M25 Junction 10/A3 Wisley Interchange Improvement Plan

I enclose written representations on behalf of the Guide Association Trust Corporation and Girlguiding Greater London West ("GGLW").

Written representations on behalf of the Girl Guiding Greater London West and Guide Association Trust Corporation

ATKINS Epsom Gateway, Ashley Avenue, Epsom, Surrey, KT18 5AL. Tel: +44 (0)1372 726140, Fax: +44 (0)1372 740055, www.atkinsglobal.com

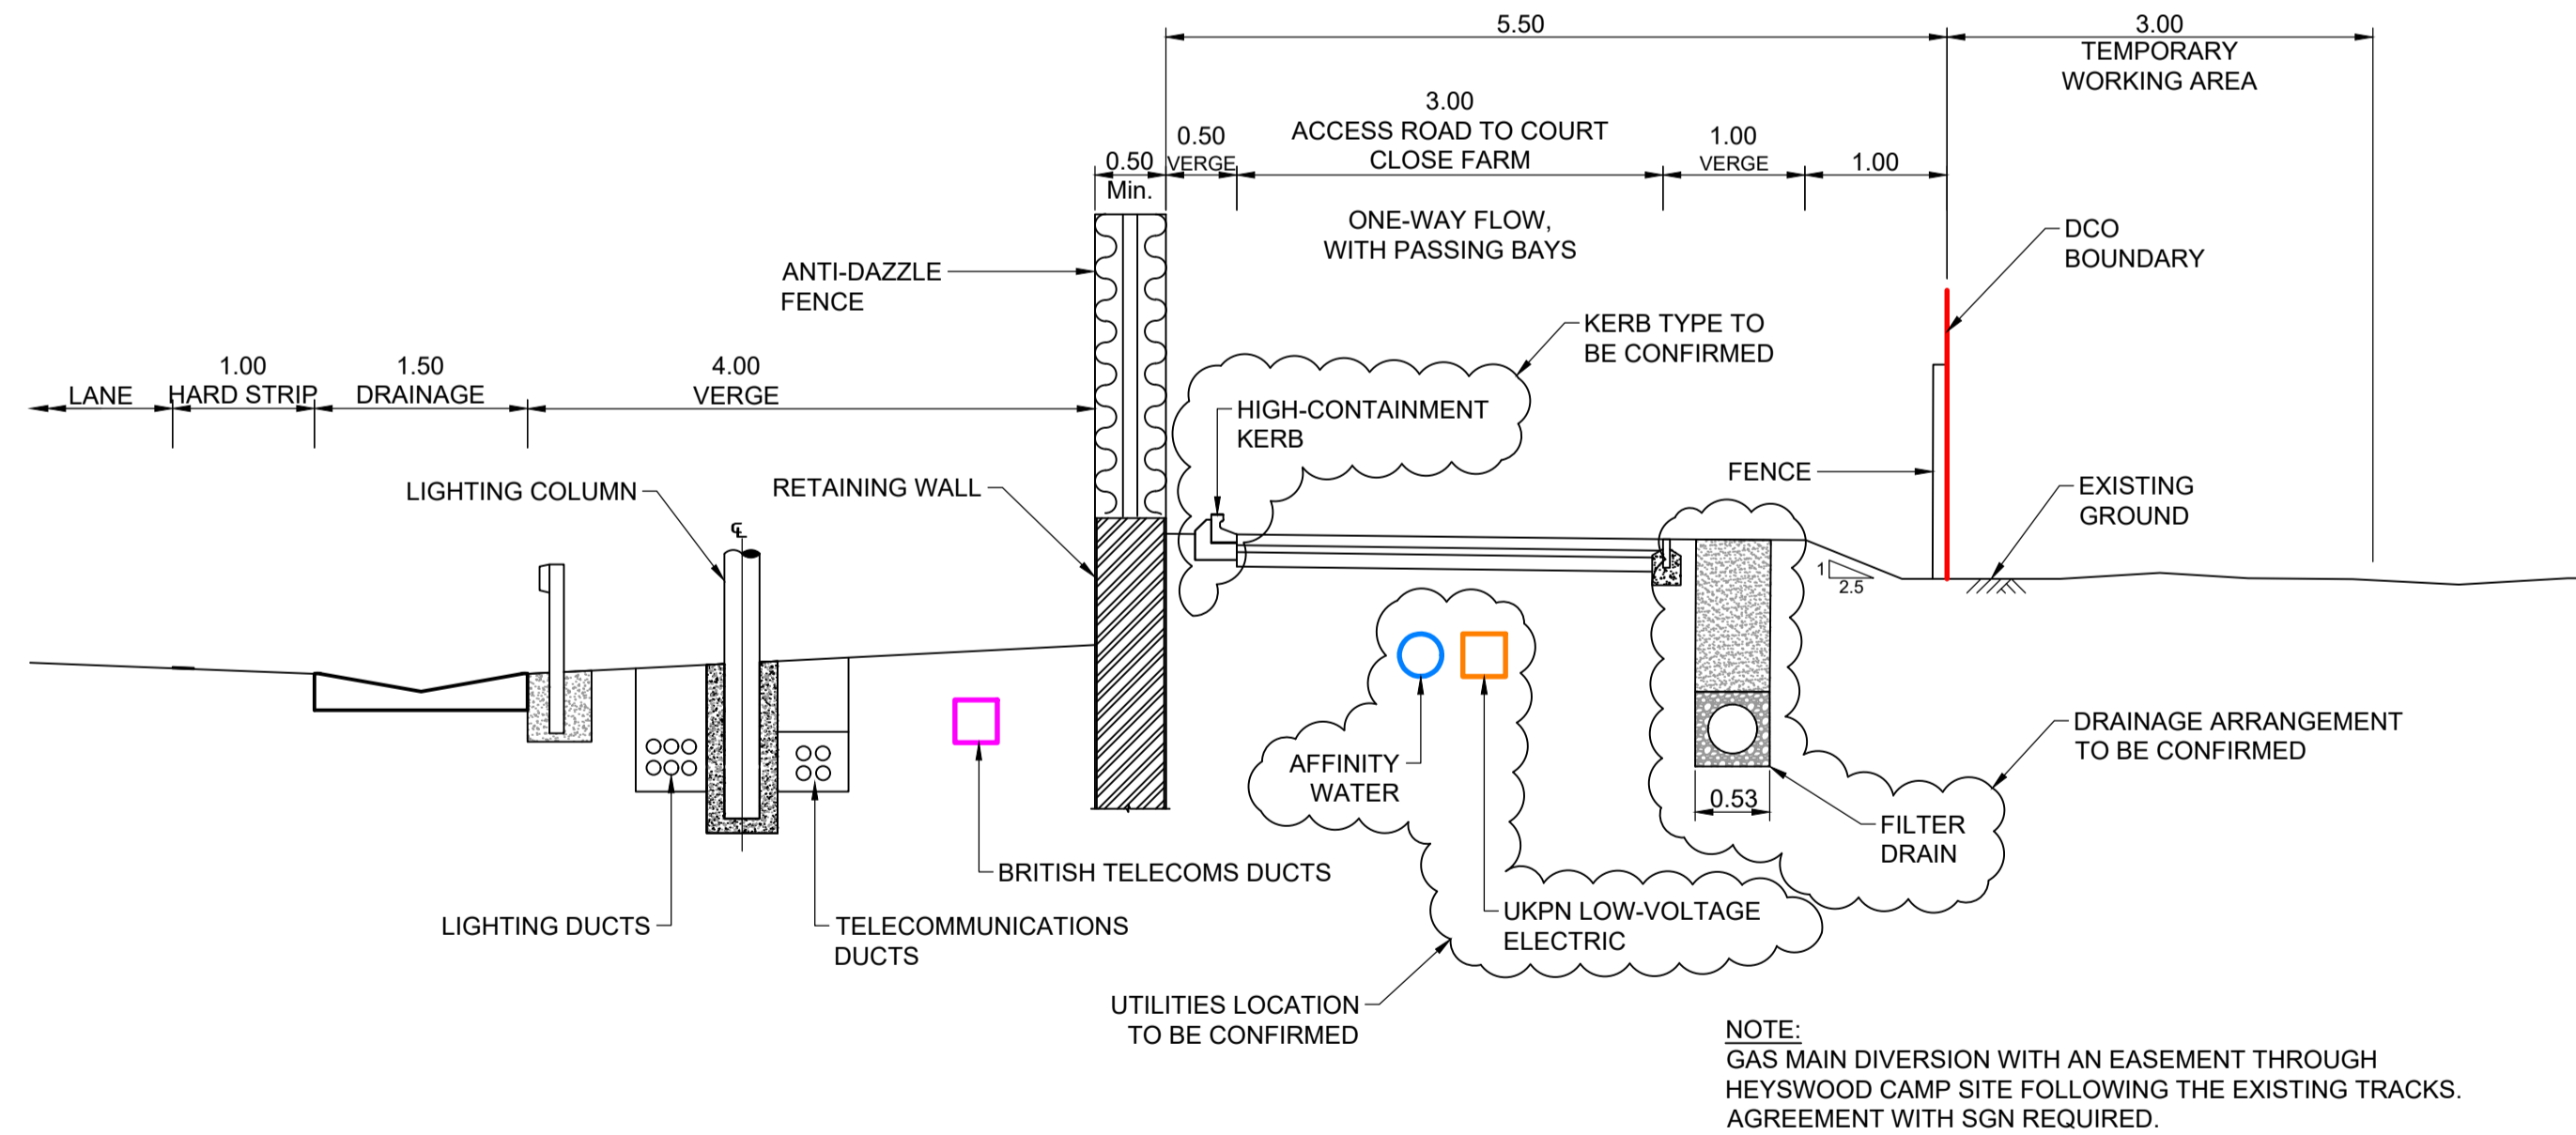
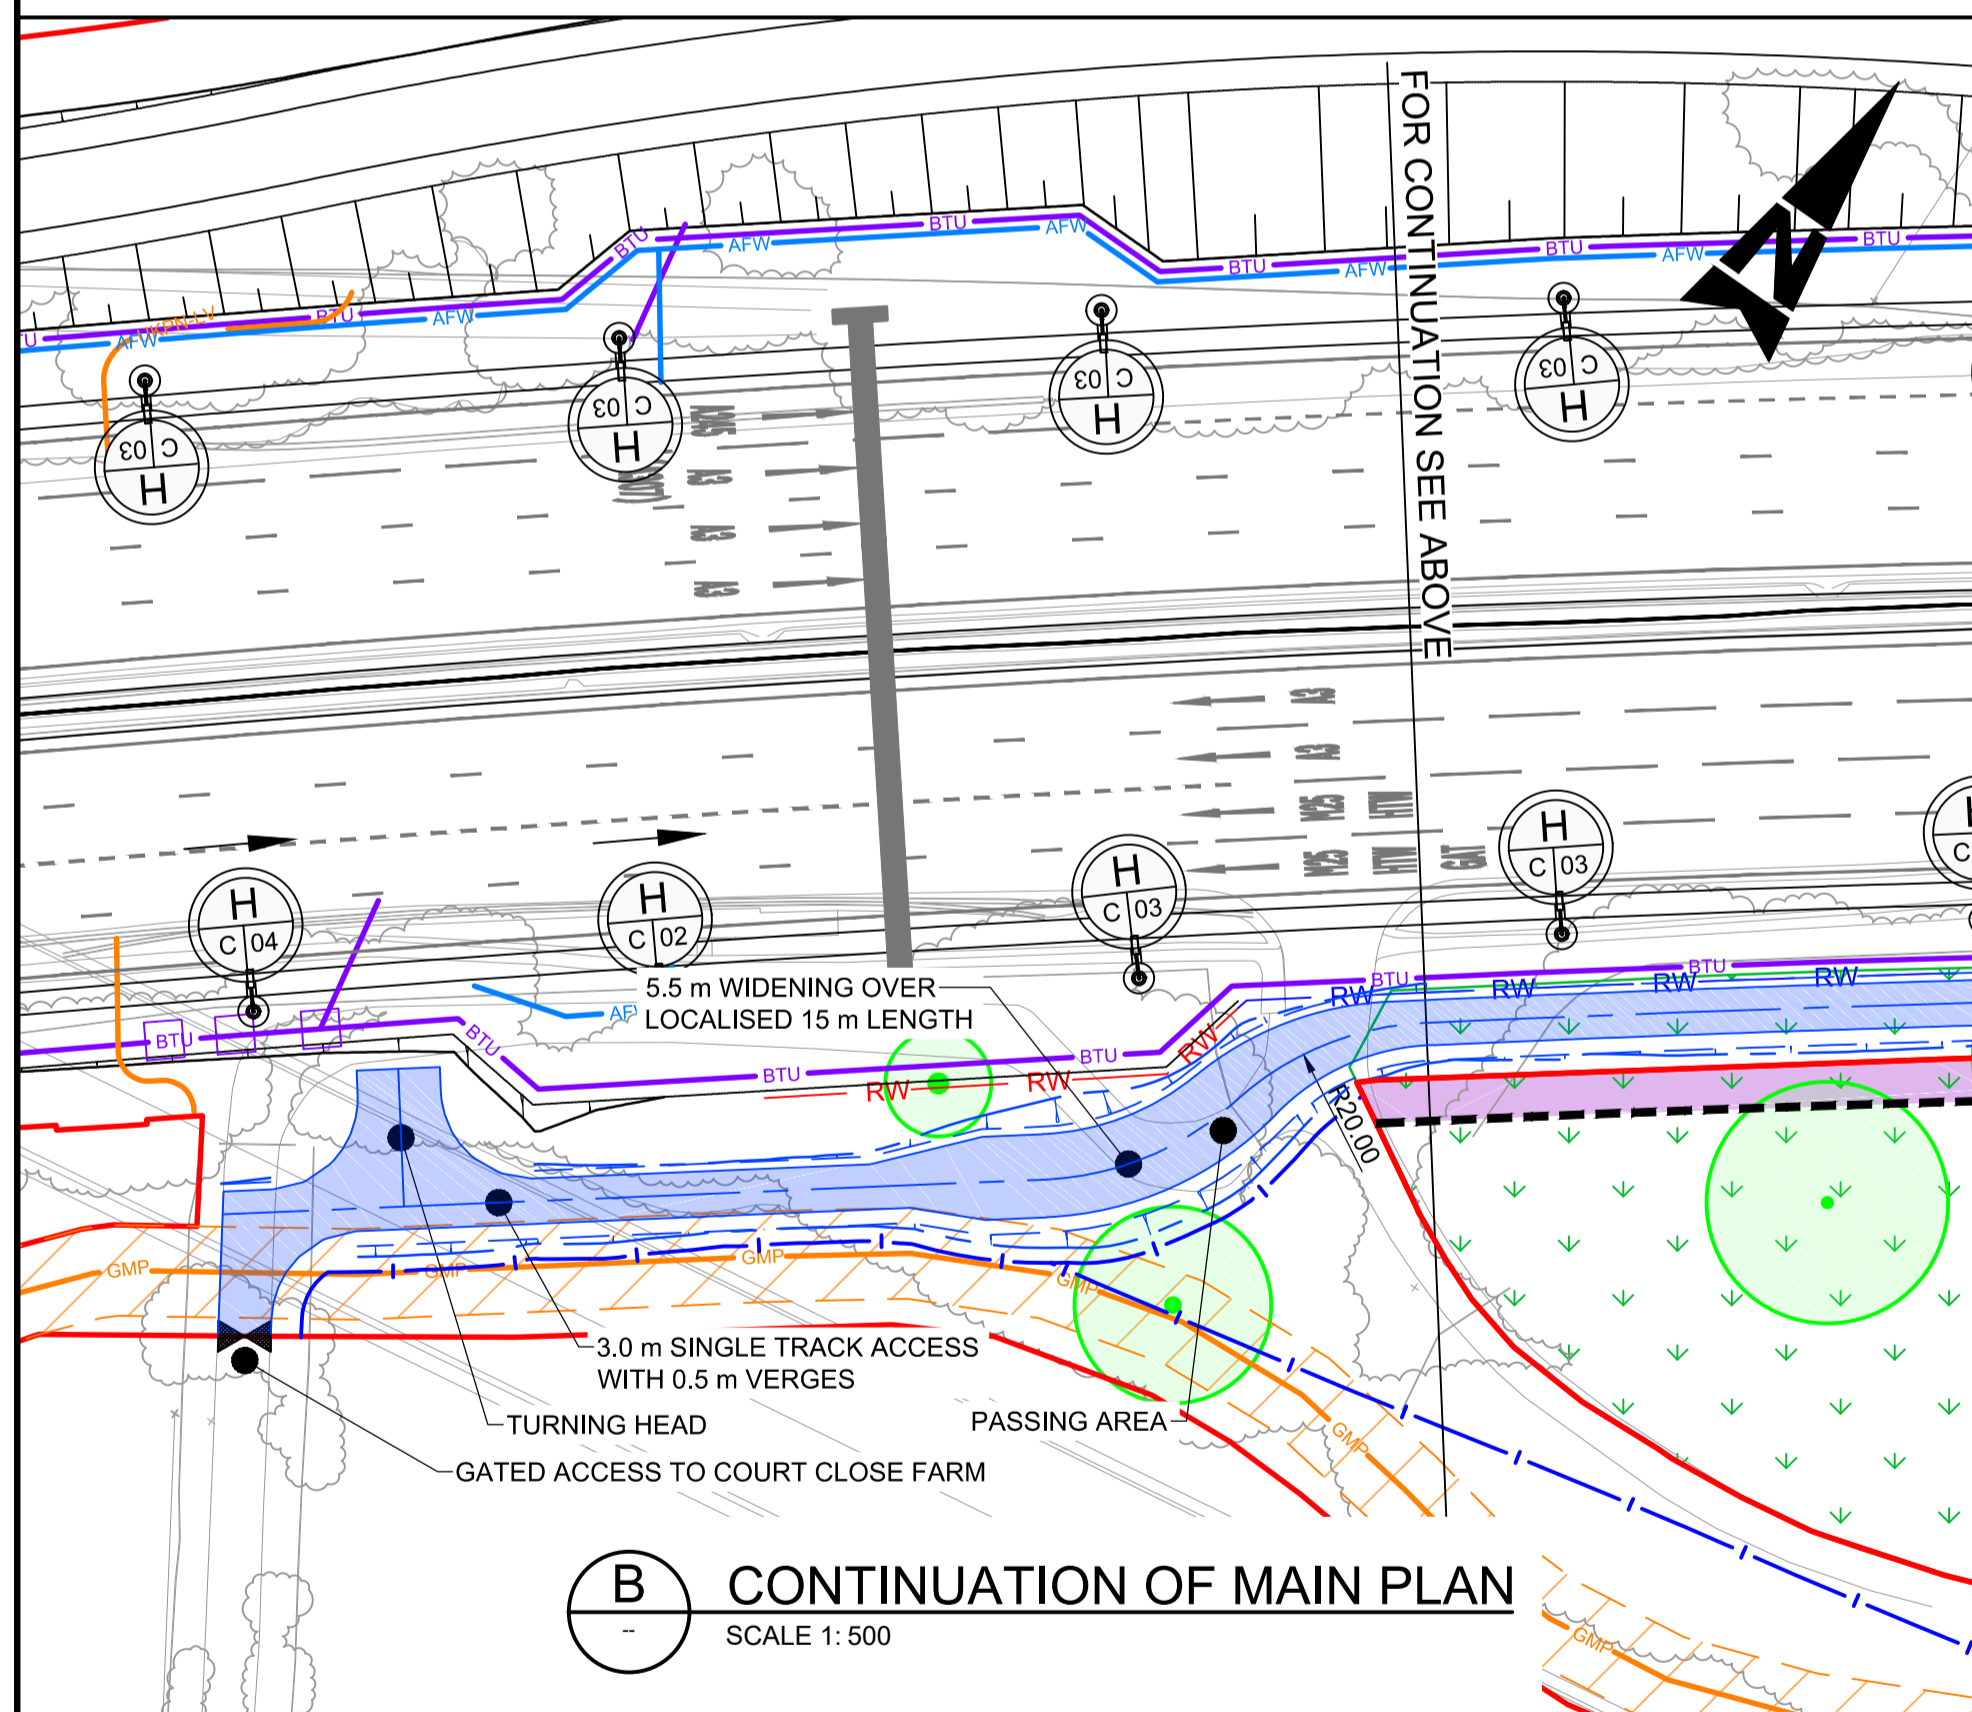
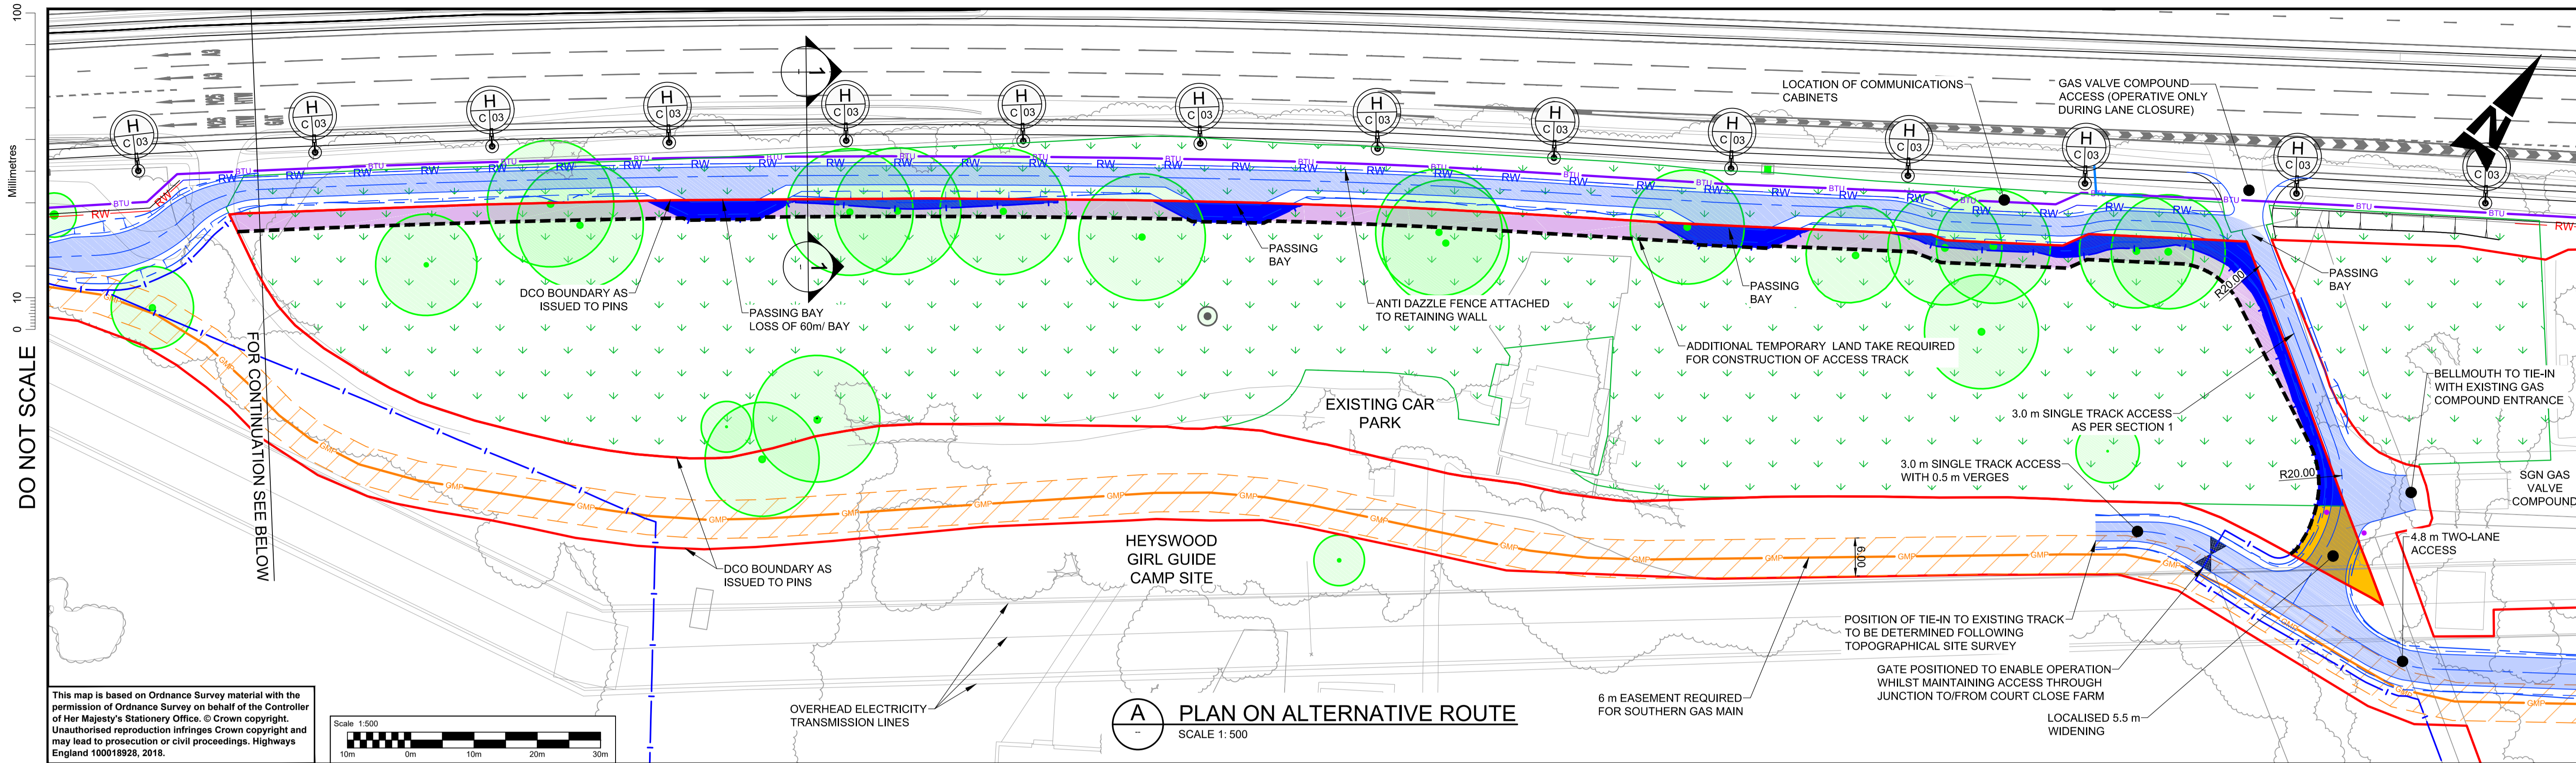
- (1) that the current proposed access is flawed and should not be consented; and
 - (2) that a far better alternative would be to locate the new access route further to the north (“the GGLW Alternative”), so that it can run along the edge of the widened A3.

3. In these circumstances, GGLW asks the ExA to require the Developer to explain its reasons for not selecting the GGLW Alternative (which was discussed with the Developer at 2018) and submits that the DCO is flawed and should not be consented in its current form.

10. The alternative which GGLW have previously discussed with the Developer would be to relocate the access road closer further to the north, so that it runs alongside the widened A3. This would:

- Minimise the necessary land take from GGLW;
 - Avoid the “sterilisation” of any additional portion of the Campsite by subdivision;
 - Facilitate the provision of security measures; and

- Reduce the environmental impacts of the access road.
11. Although the Developer’s reasons for not adopting the GGLW alternative have never been properly explained to GGLW, it is believed that the core reason is that further land take next to the A3 southbound lane would result in additional loss of Ancient Woodland.
